From: P J Gaylor [REDACTED]
Sent: 25 July 2021 13:23
To: Kathryn Welch <Kathryn.Welch@arun.gov.uk>
Subject: Y/96/21/CLP

As noted in your email there were conditions attached to the original planning application, namely condition No.7 which restricts the building of extensions and building within the curtilage of the dwelling house. I shall view the application documents submitted against this and the subsequent DOC applications to determine whether or not the application is allowable or whether the applicant is required to submit a full planning application.

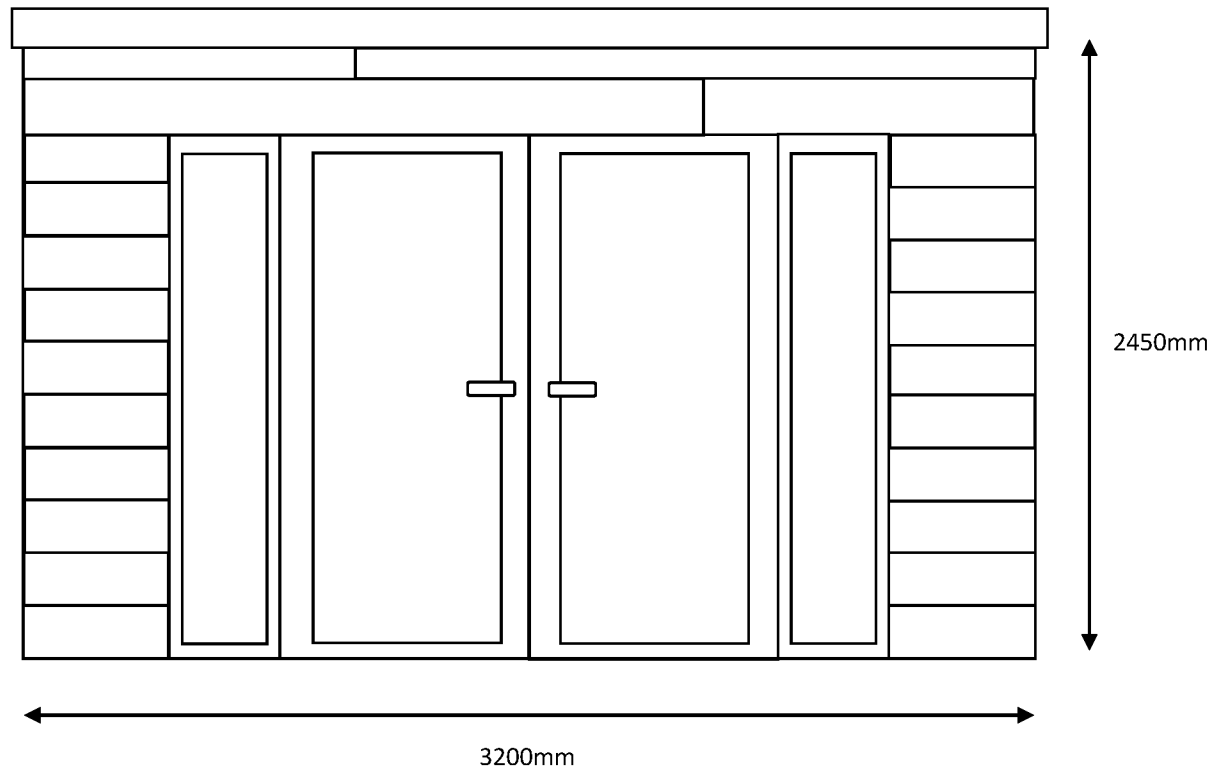
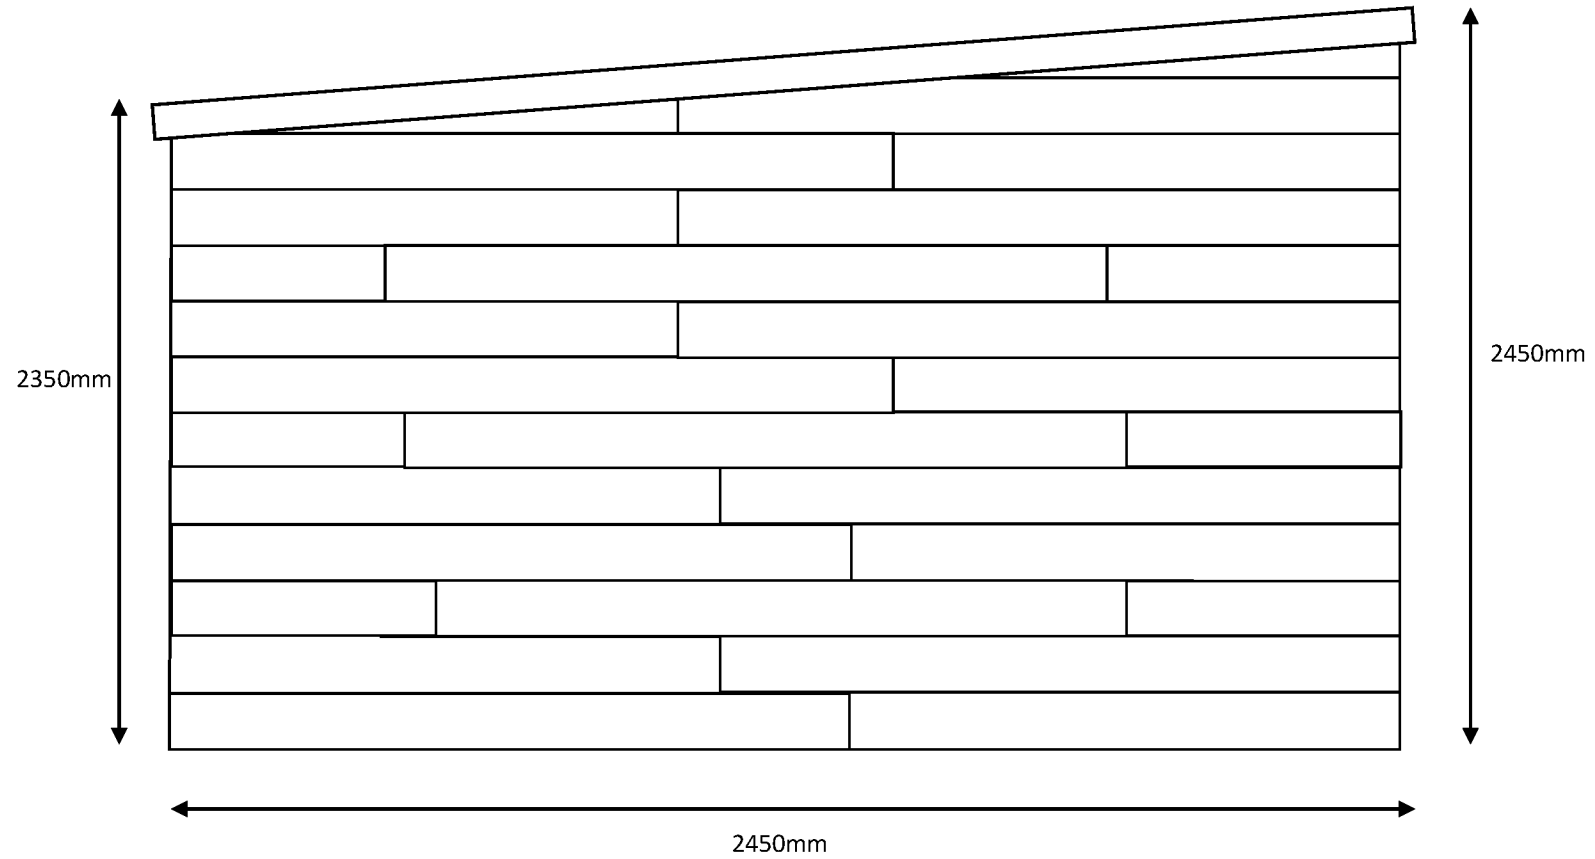
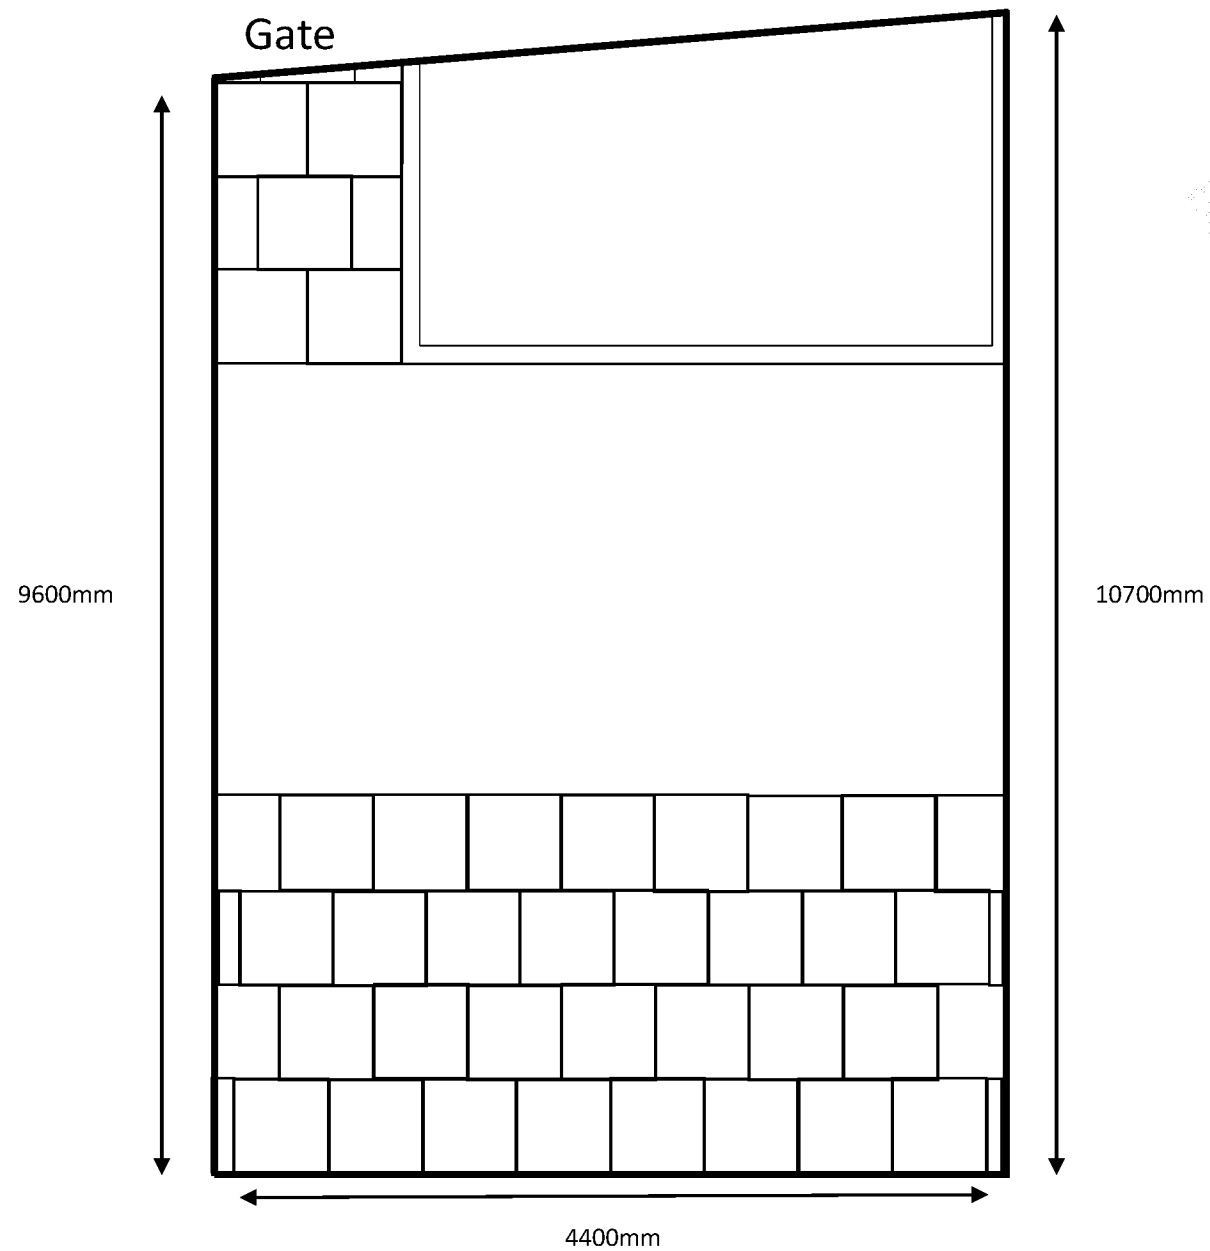
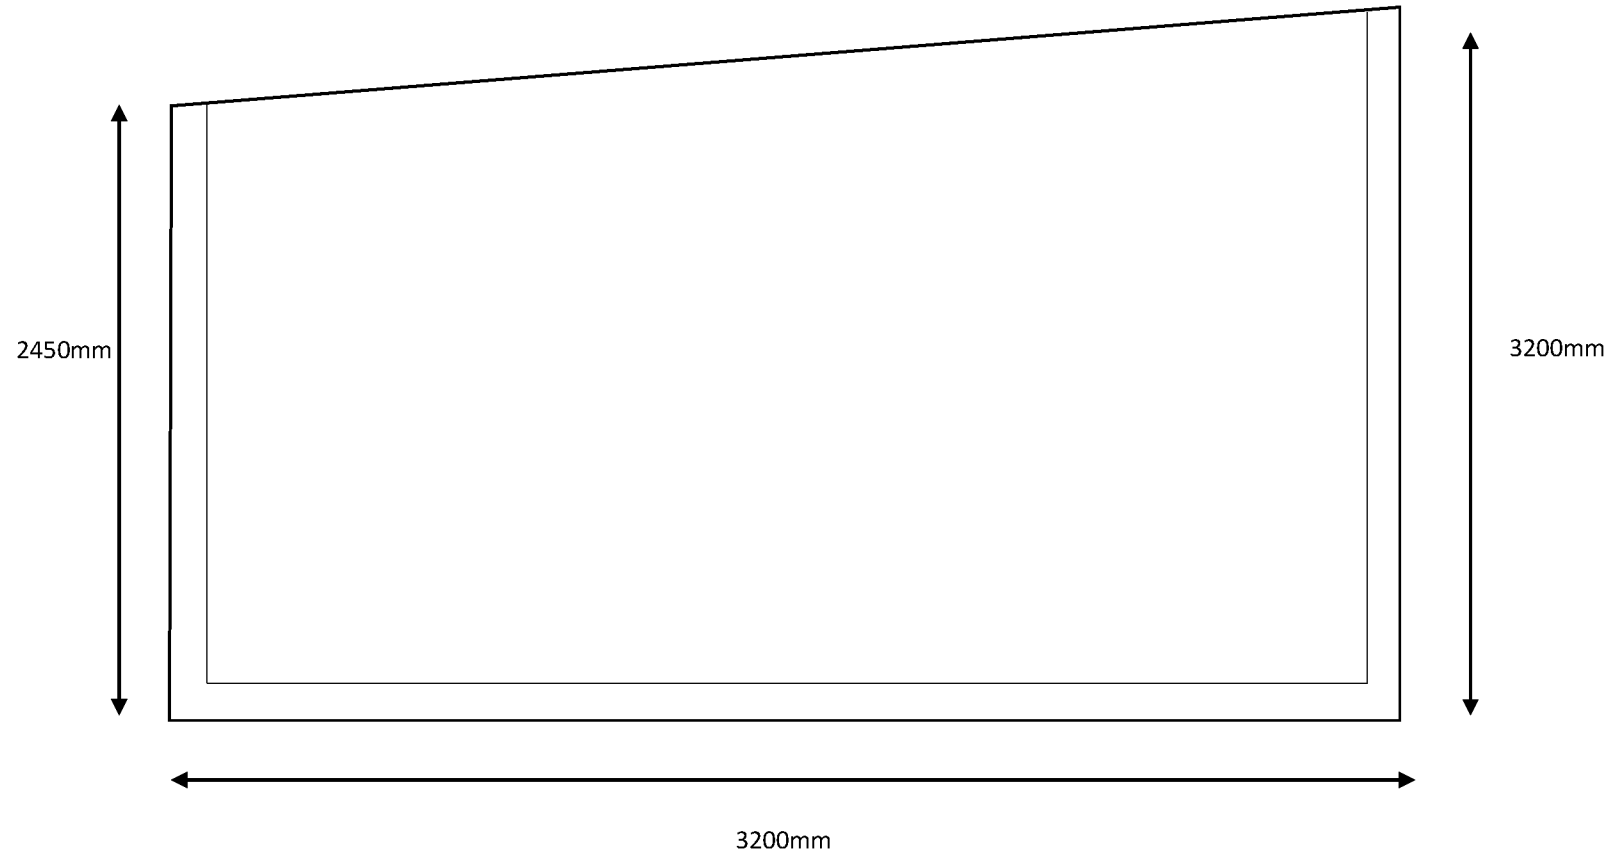
Our main concern is of scale and size which we believe to be unnecessary, overpowering and disproportionate to the garden size and development. It is just far too high!
